Recommendation Report for Planning Permission

REF NO: BR/79/21/PL

LOCATION: 83 Aldwick Road
Bognor Regis
PO21 2NW

PROPOSAL: Rear extensions and loft conversion to form enlarged HMO (Sui Generis)
(resubmission following BR/206/19/PL).

amendments	
client	SPP
project	83 Aldwick Road Bognor Regis PO21 2NT
project ref.	2446
drawing title	Existing plans
drawn by	DH
date	DEC 20
scale	1:50/100@ A1
	www.bpmnet.co.uk info@bpmnet.co.uk
Do not scale off drawing, check all dimensions on site before all work is commenced

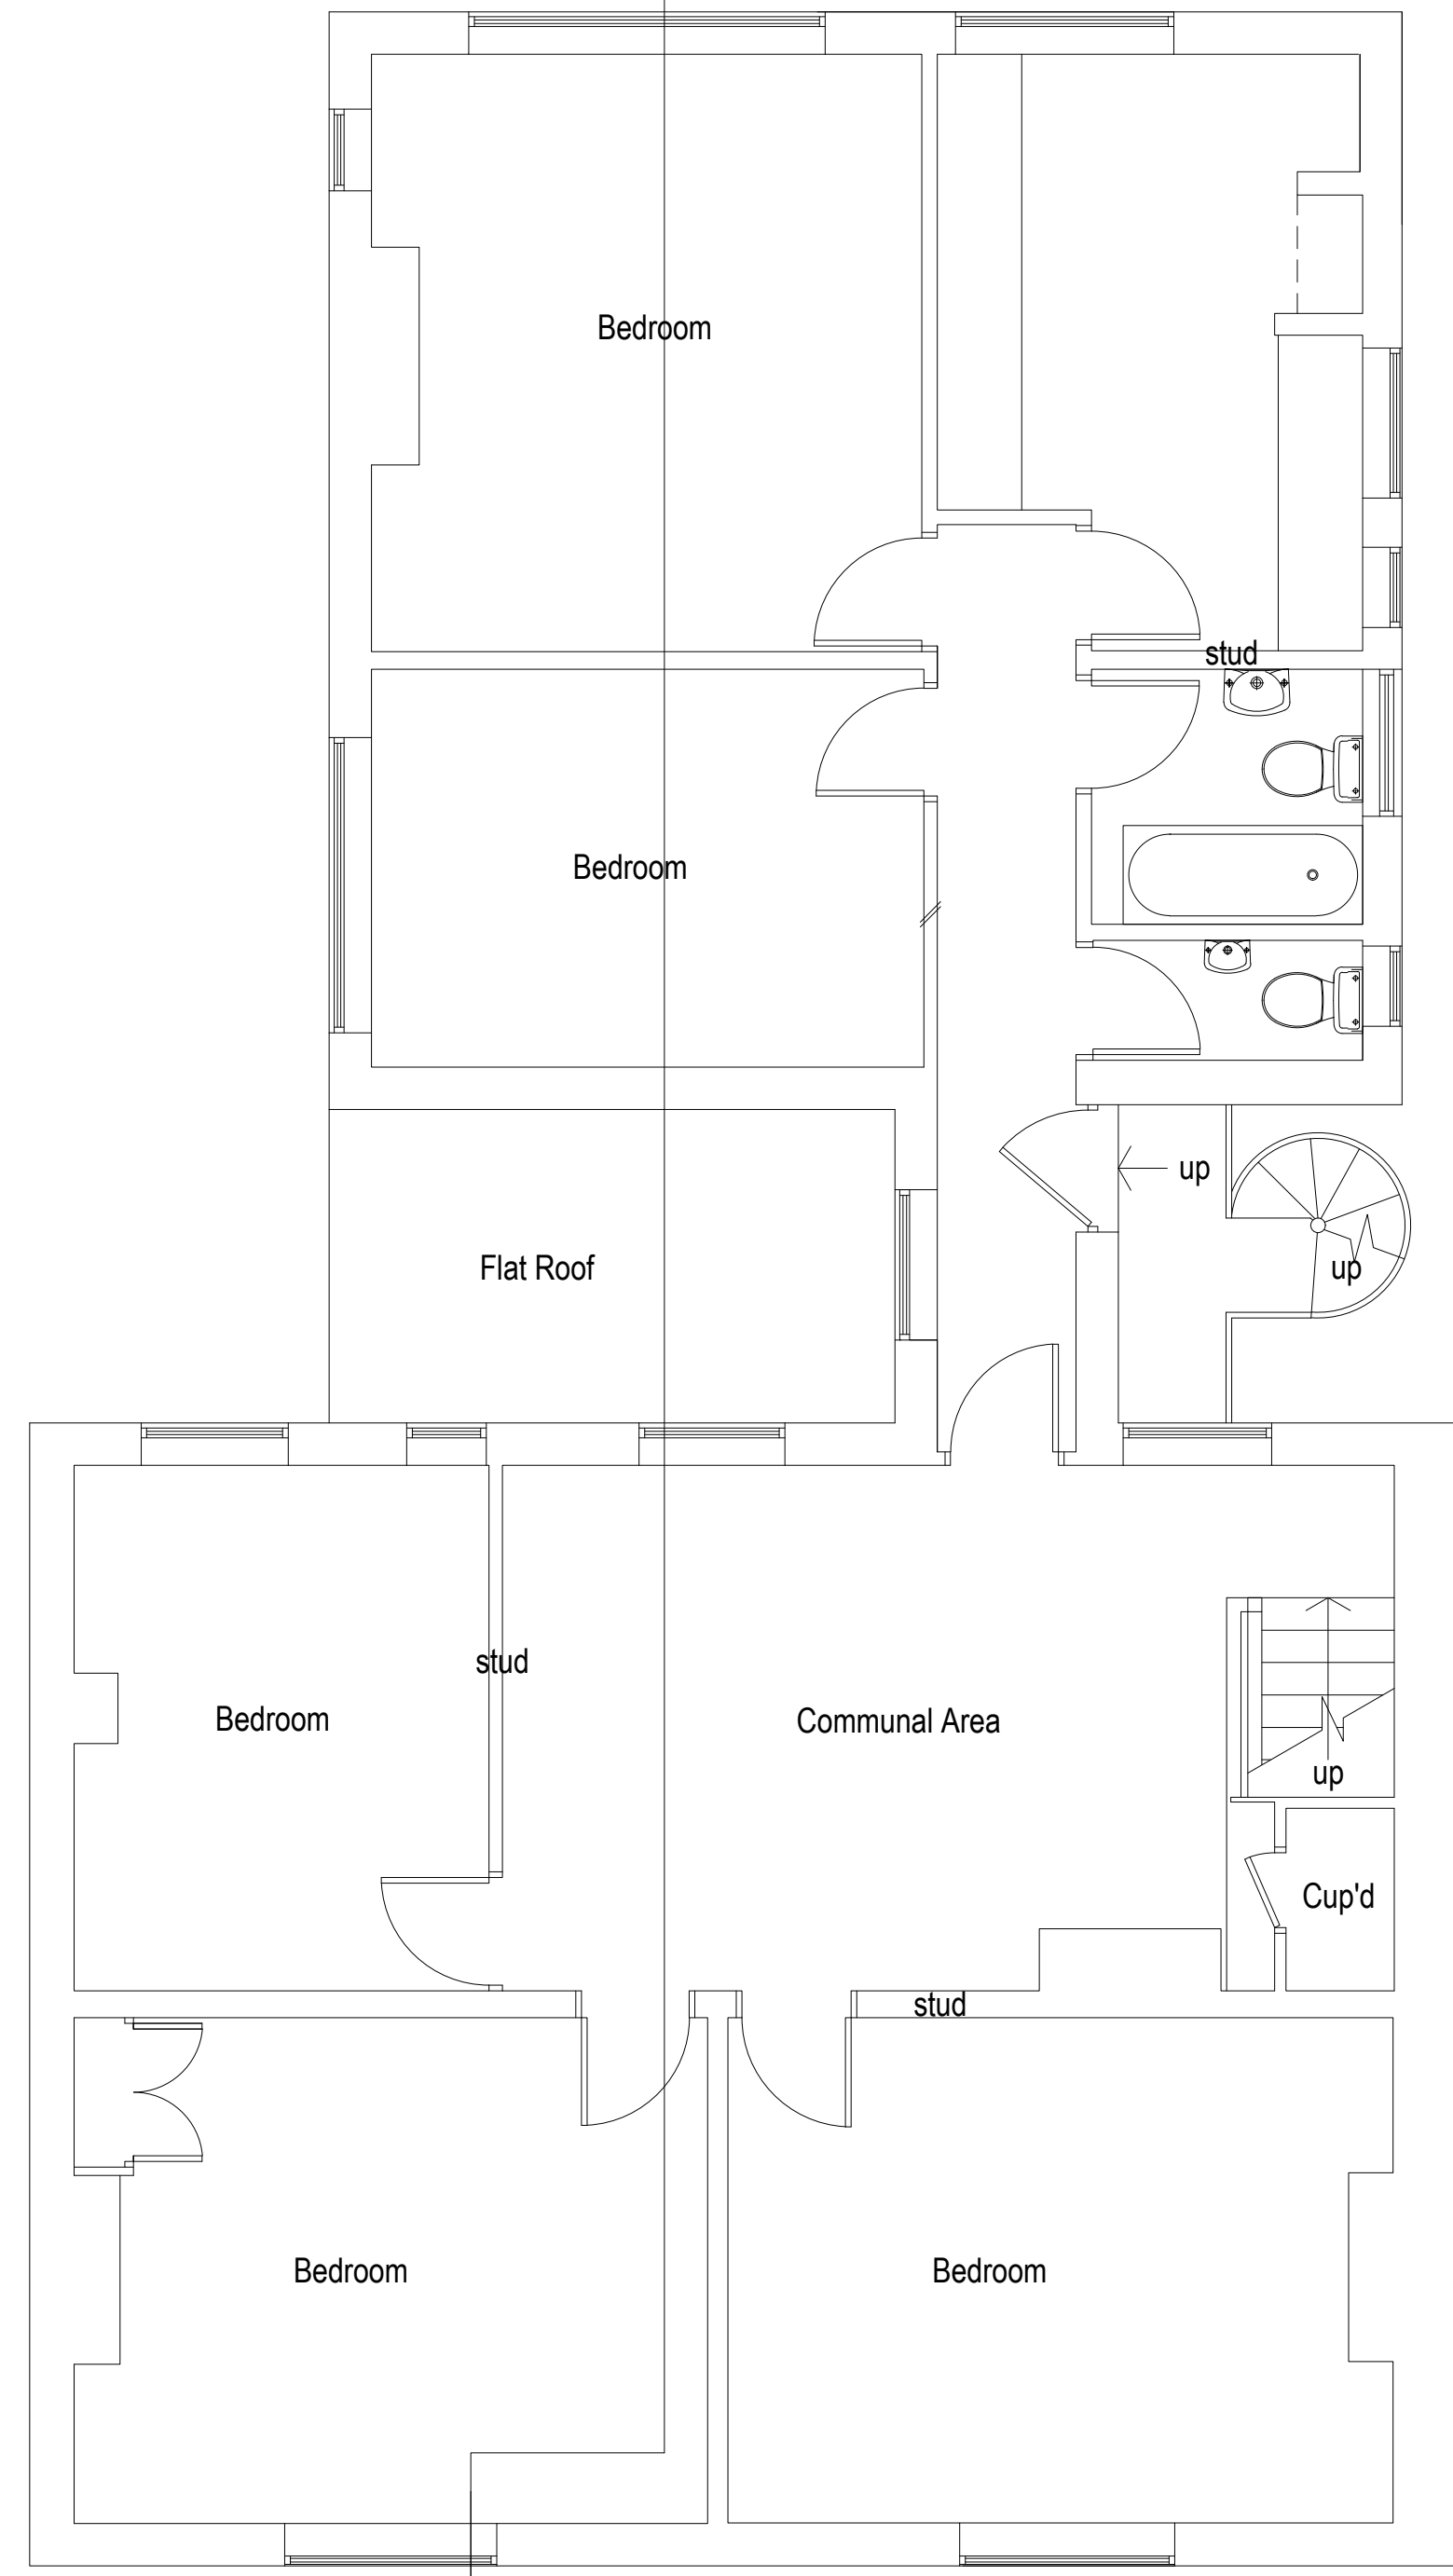
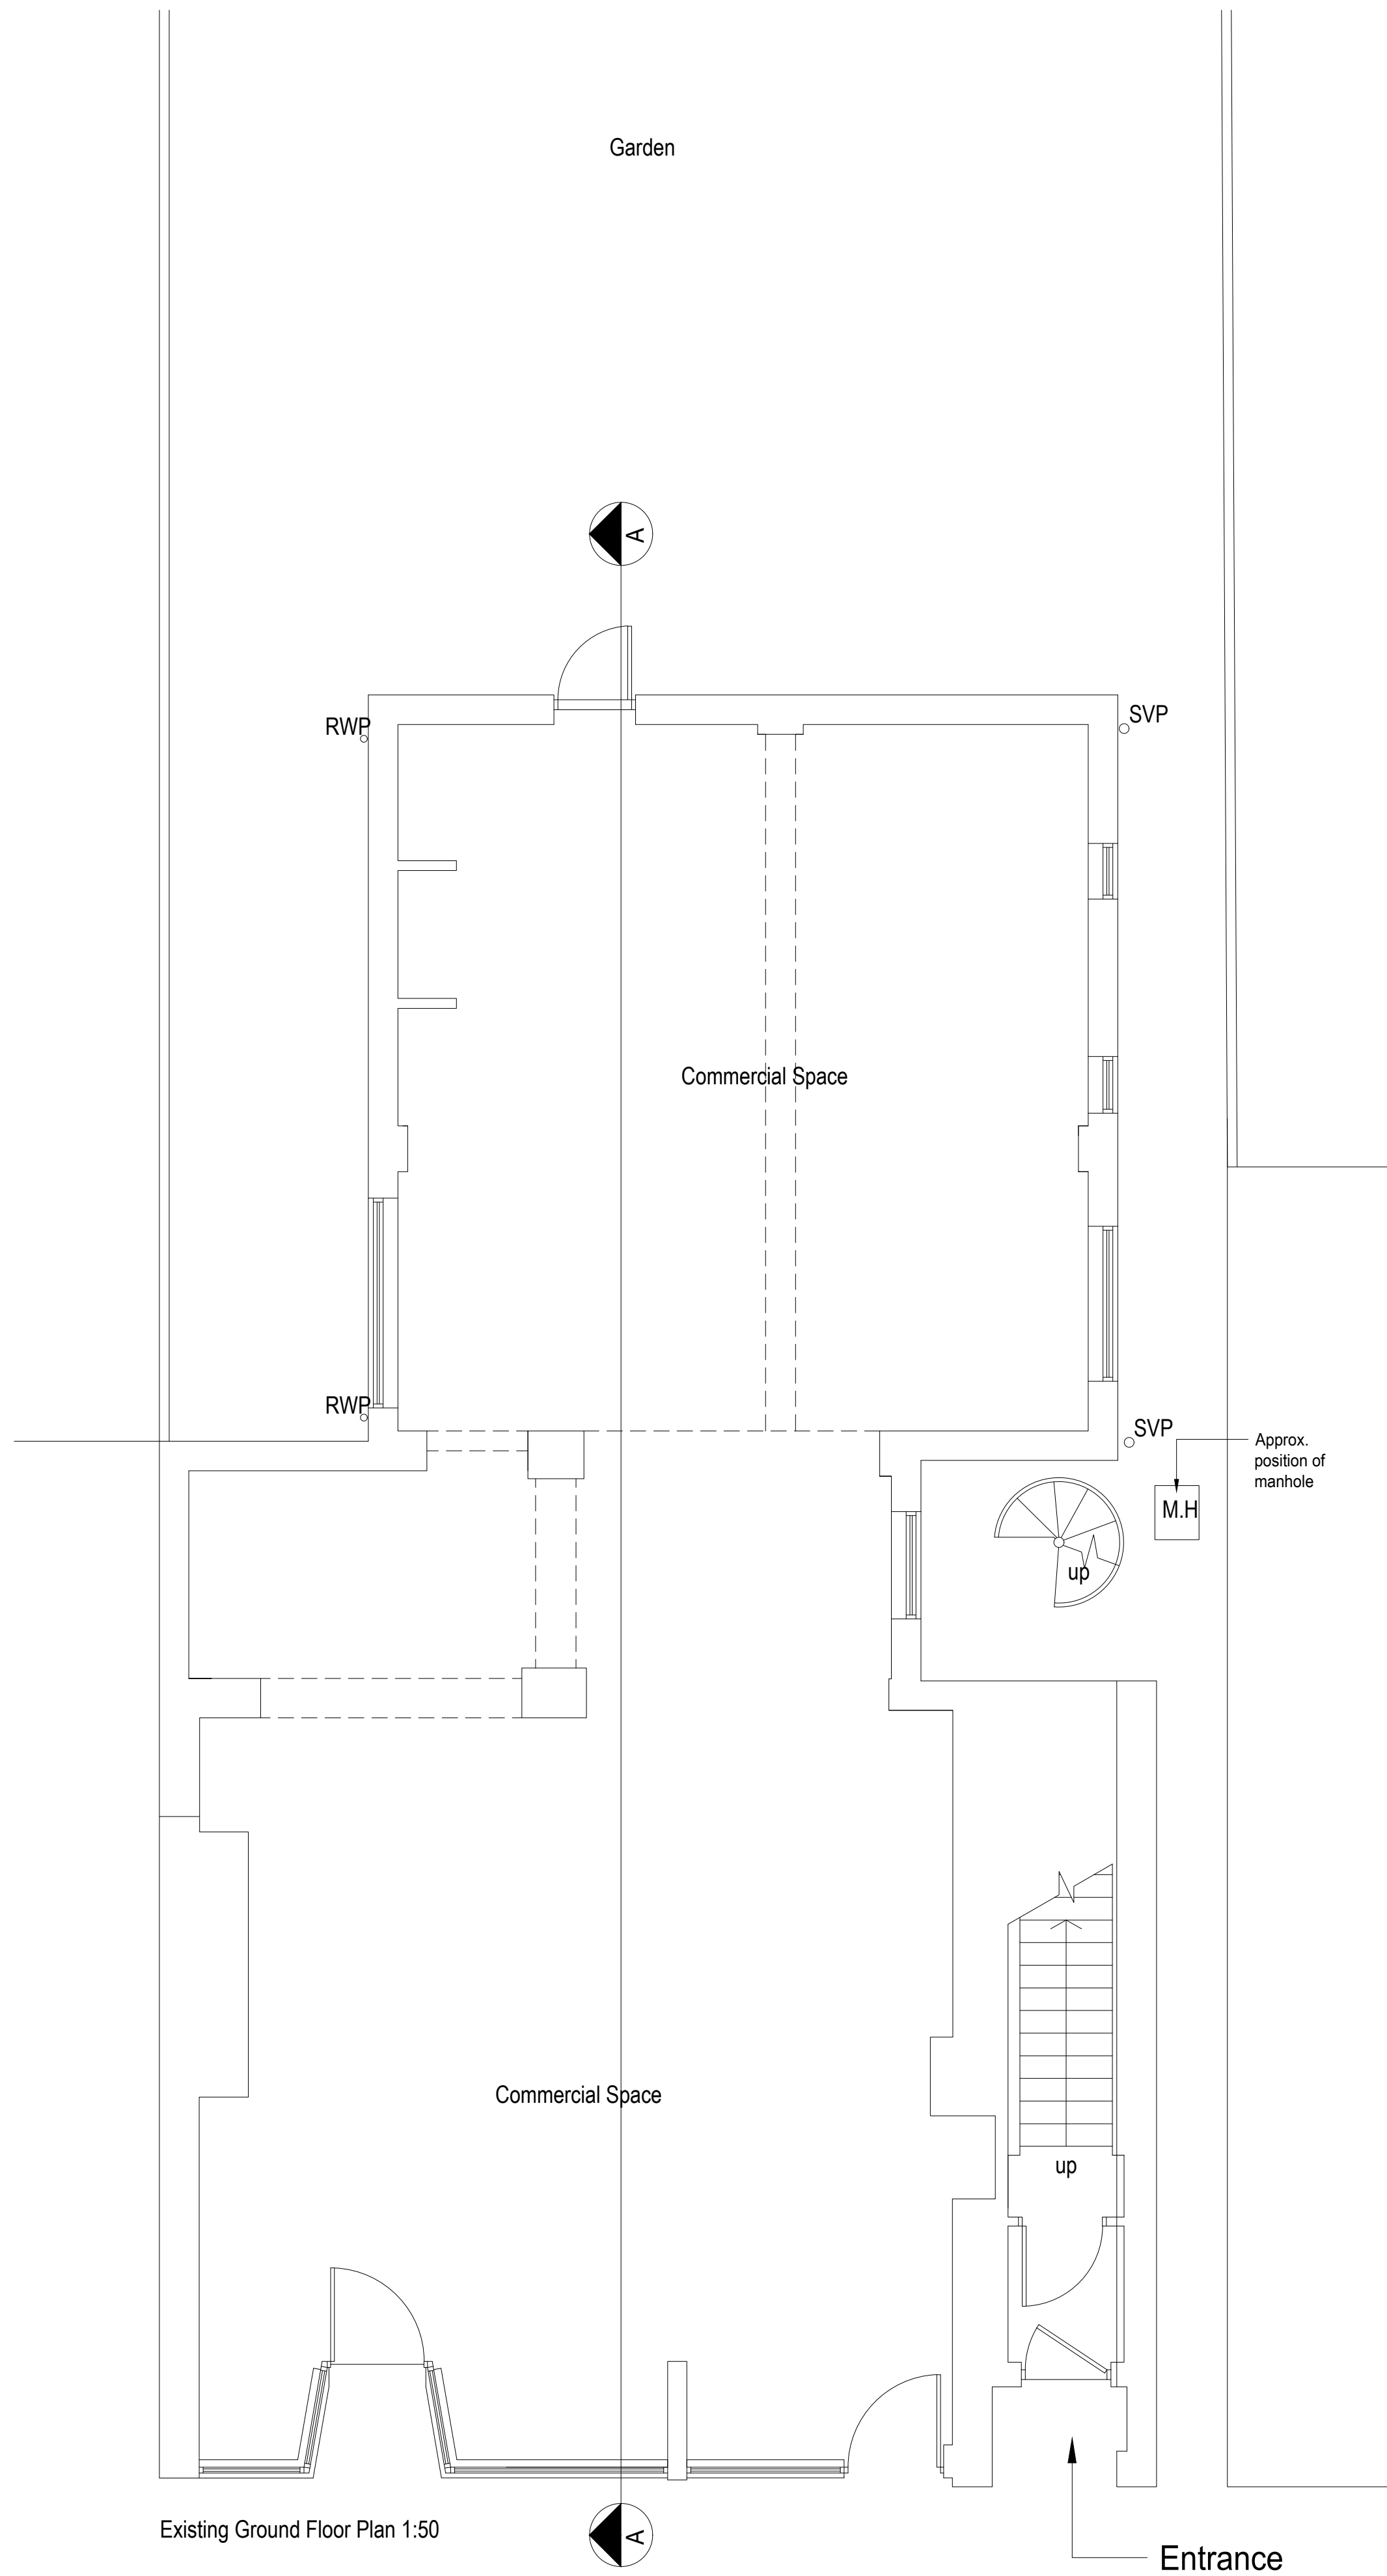
The second floor rear extension would comprise approximately 3.6m of additional height with two large windows facing to the south and one to the east, facing to the west elevation of neighbouring property No 81 Aldwick Road with habitable windows at 3 floor levels within a distance of less than 5m resulting in a direct overlooking and violating the privacy of occupiers of this property and the prospective residents of the proposal property. In addition, the proposed extension due to its position to the west from No 81 and its proximity would result in significant loss of sunlight and outlook of occupiers of No 81. The distance between rear windows and an existing habitable windows of properties along Stocker Road would be more than 20m.

Taking the above into account, the proposed second floor extension would result in a loss of sunlight, privacy and outlook of residents at No 81 Aldwick Road by virtue of its height, location, proximity and detailed design that would impact upon their private amenities and living conditions, contrary to policies D SP1, D DM1, D DM4 and QE SP1 of the Local Plan and paragraphs 11(d)(ii), 117, 123 and 127 of the NPPF(2019).

- 2 The second floor extension above the rear extension of No 83 Aldwick Road will result in a significant loss of sunlight, privacy and outlook of occupiers at No 81 Aldwick Road. The proposal is therefore contrary to policies D SP1, D DM1, D DM4 and QE SP1 of the Arun Local Plan and the National Planning Policy Framework.
